WATERBURY SANITARY FORCE MAIN
UTILITY CONSTRUCTION SET
LEGEND SHEET

WATERBURY SANITARY FORCE MAIN
 UTILITY CONSTRUCTION SET
 SANITARY FORCE MAIN PLAN & PROFILE

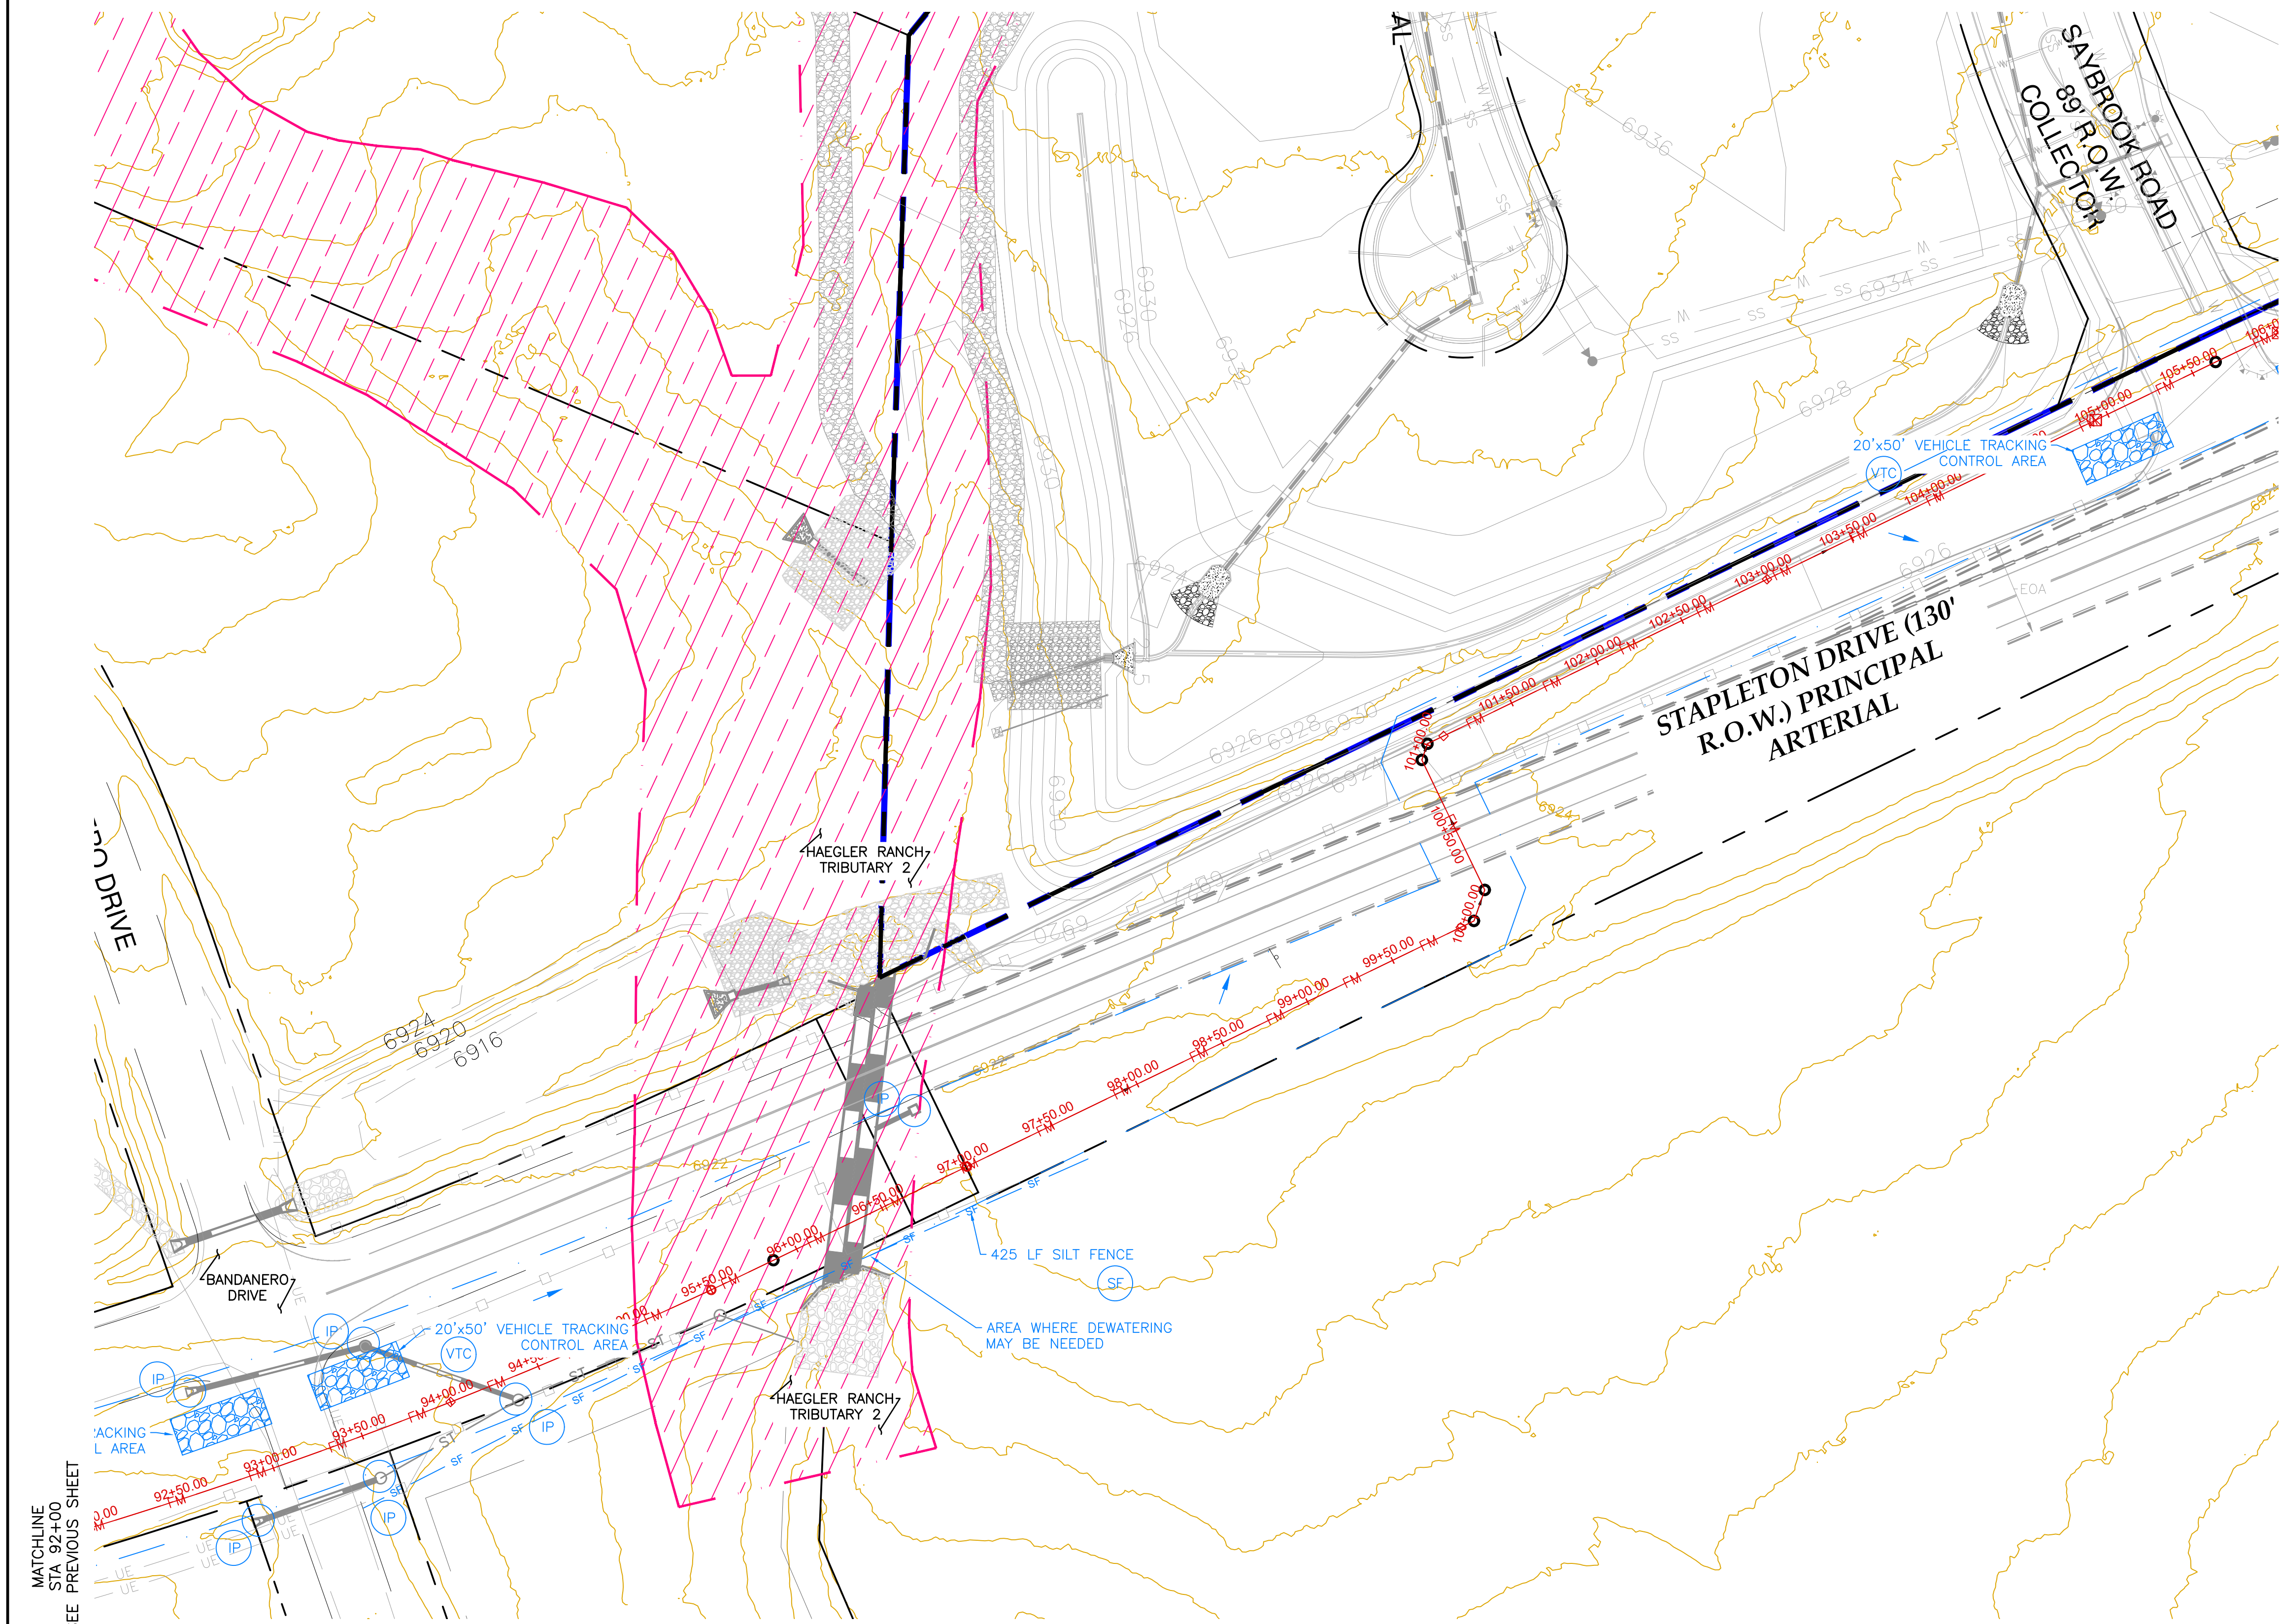
Resolved - dotsaleh
 Add the following note to the cover sheet: Access will be provided to all parcels abutting the open cut to the proposed FM and the contractor must perform this coordination with each parcel owner.
 I added this to the cover sheet, #16 under notes.

Resolved - dotsaleh
 Typical comment: Indicate the following for each parcel: Parcel number, parcel address and owner name.
 I added this to the overview sheet.

Resolved - dotsaleh
 Typical comment: Indicate the following for each parcel: Parcel number, parcel address and owner name.
 I added this to the overview sheet.

UTILITY CONSTRUCTION SET
SANITARY FORCE MAIN PLAN & PROFILE

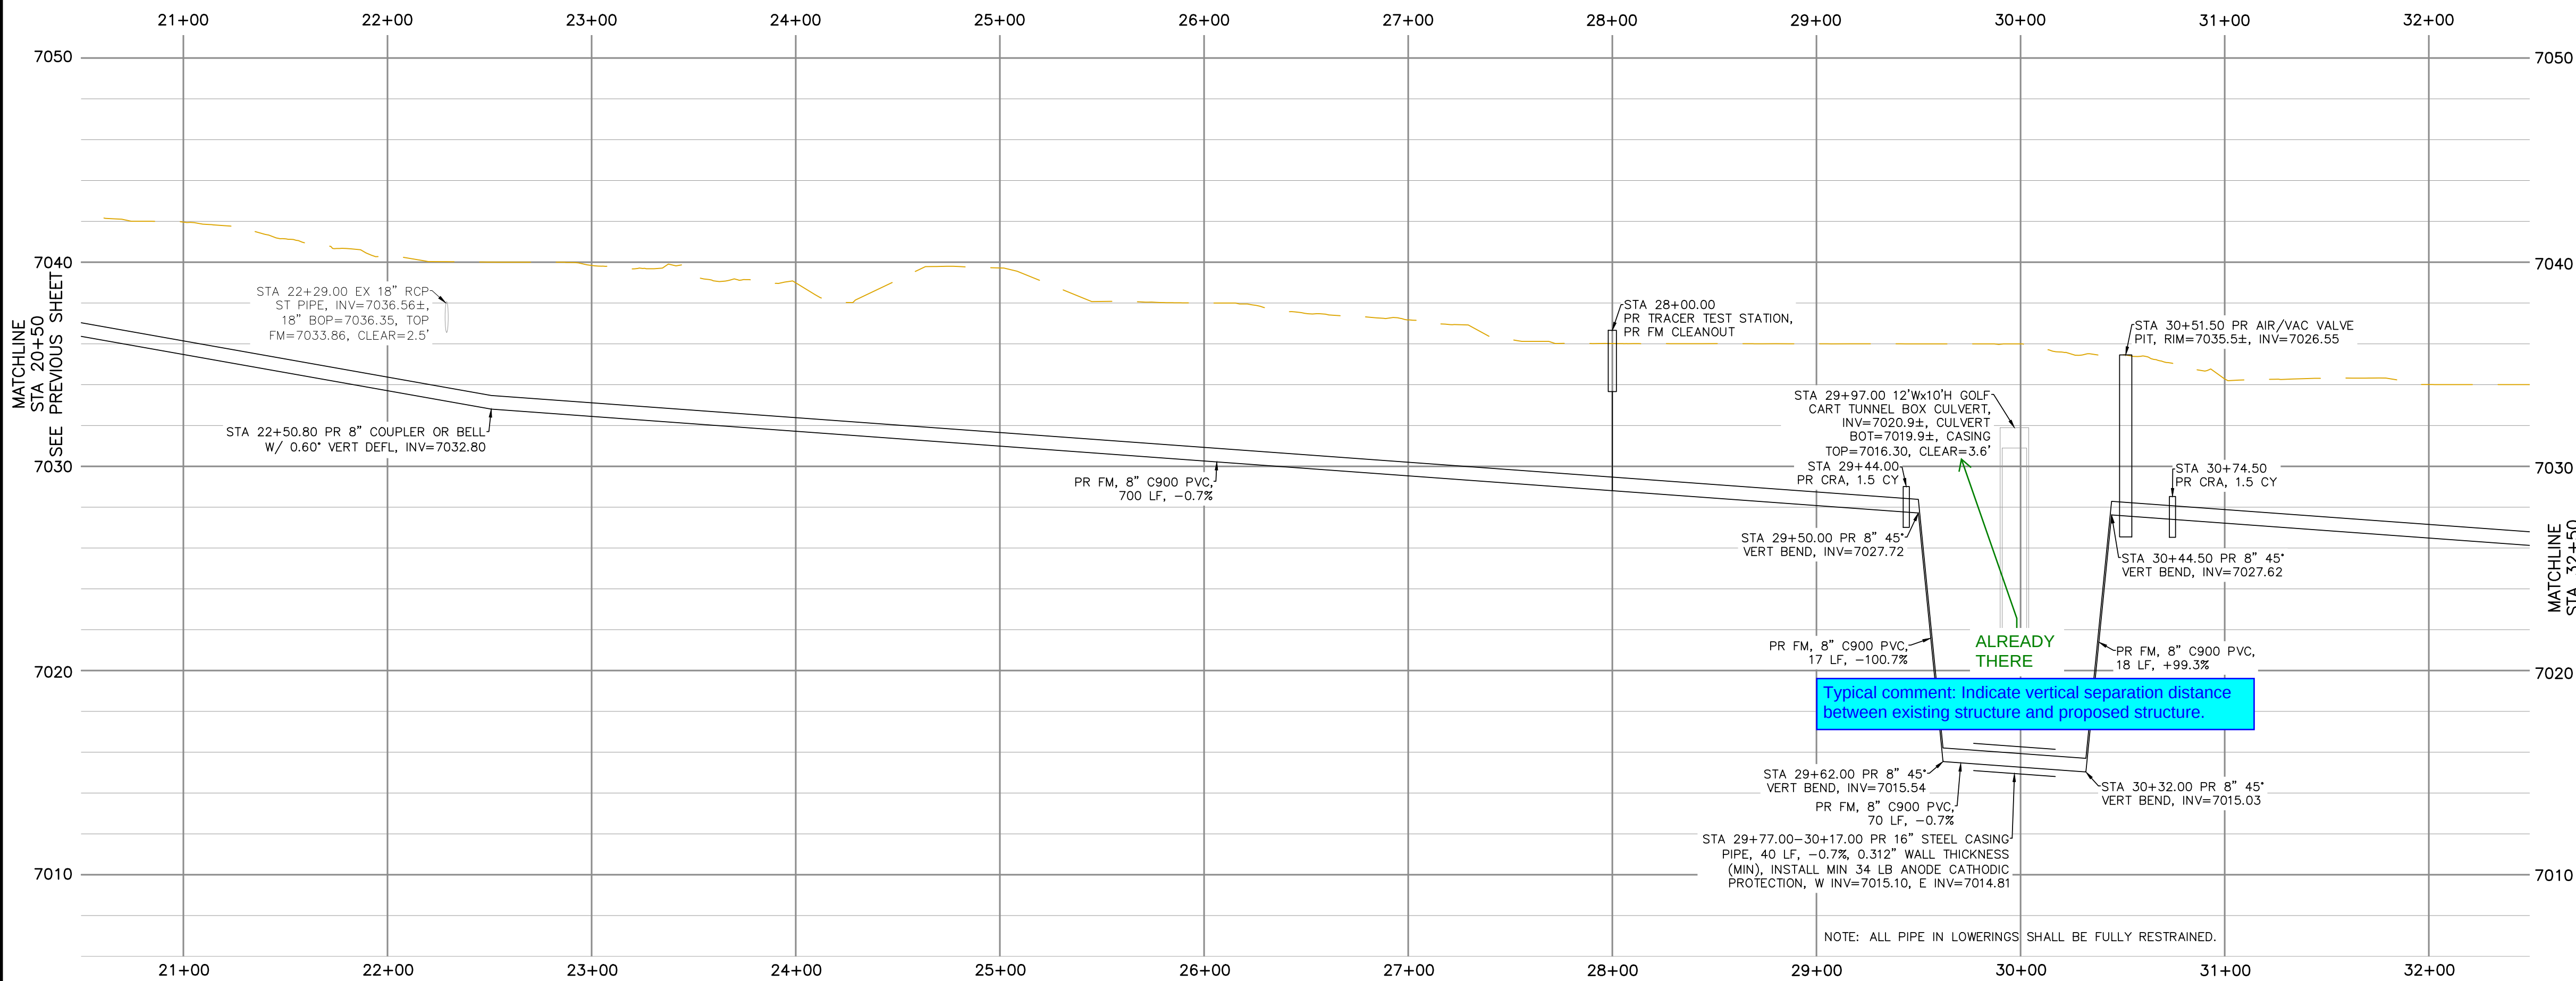
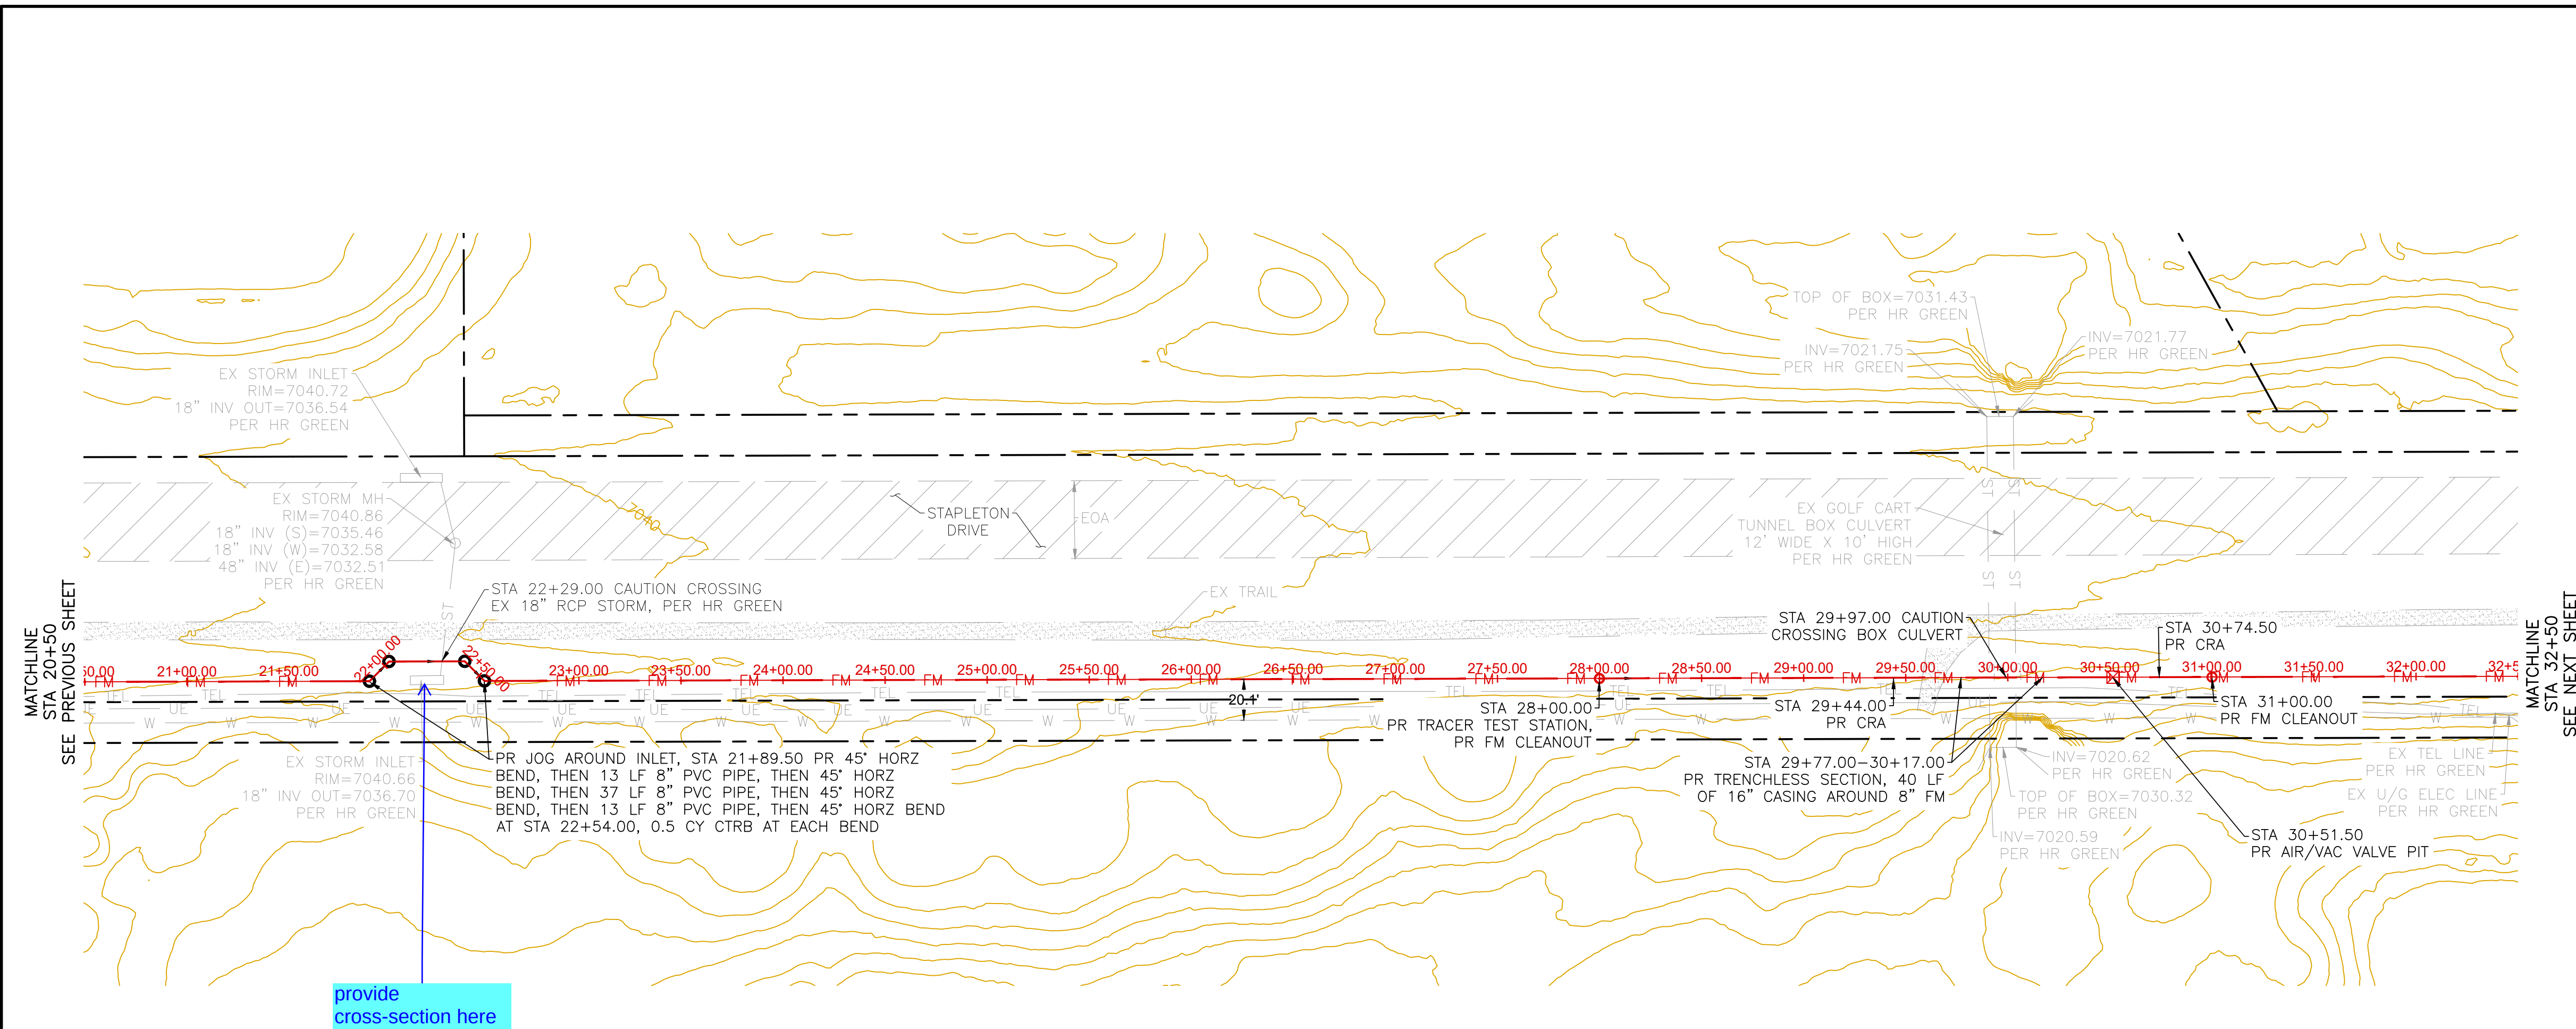
I added this to the cover sheet under notes.
 Add the following note: "the open cut shall not exceed 250 LF per day, the developer can not block the road. The developer can not block it at the end of the same day and make it safe to the public (No open cut to remain open after working hours)."
 Resolved - dotsaleh
 06/18/2026 11:11:20 AM

I added this to the cover sheet. Resolved. 06/18/2026 11:15:25 AM
 Add the following note "the open cut shall not exceed 24" E per day, the developer can not open ground if he/she can not back fill it at the end of the same day and make it safe to the public (No open cut to remain open after working hours)".
